Your Ref: SSD-9601

28 February 2020

**SSD-9601 – 780 WALLGROVE ROAD, HORSLEY PARK – PROPOSED
UPGRADES TO PLANT 2 – RESPONSE TO SUBMISSIONS**

**Figure 7 | Proposed Stormwater Detention/ Sediment Basin**

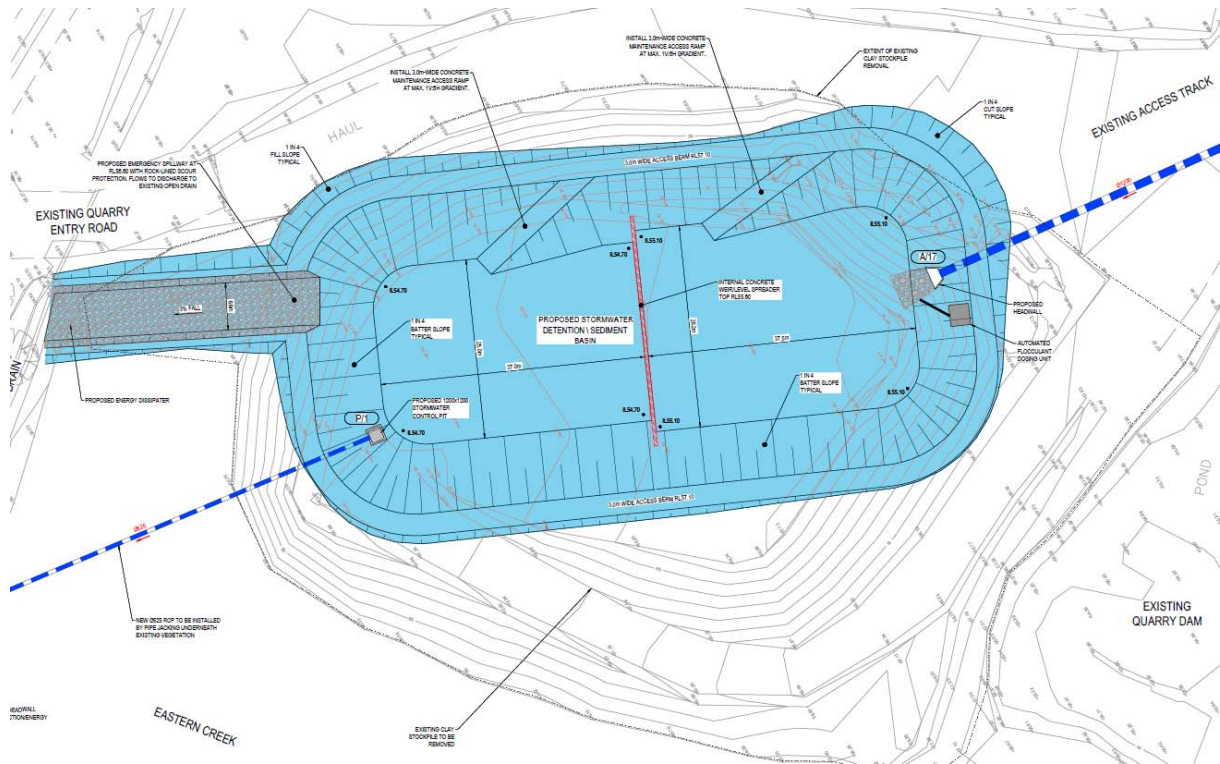
Council requires the on-site detention system to be designed in accordance with clause 4.5.1.2 of Council's Stormwater Management Policy (Sept 2017). Detailed cross section of the OSD basin shall be included in the final design. Council's Development Engineers have reviewed the applicant's response and require detailed calculations of OSD design to include stormwater plans to demonstrate the storage volume and site discharge in accordance with the Stormwater Management Policy. Plans must also provide a long section through the OSD basin and headwall at discharge point.
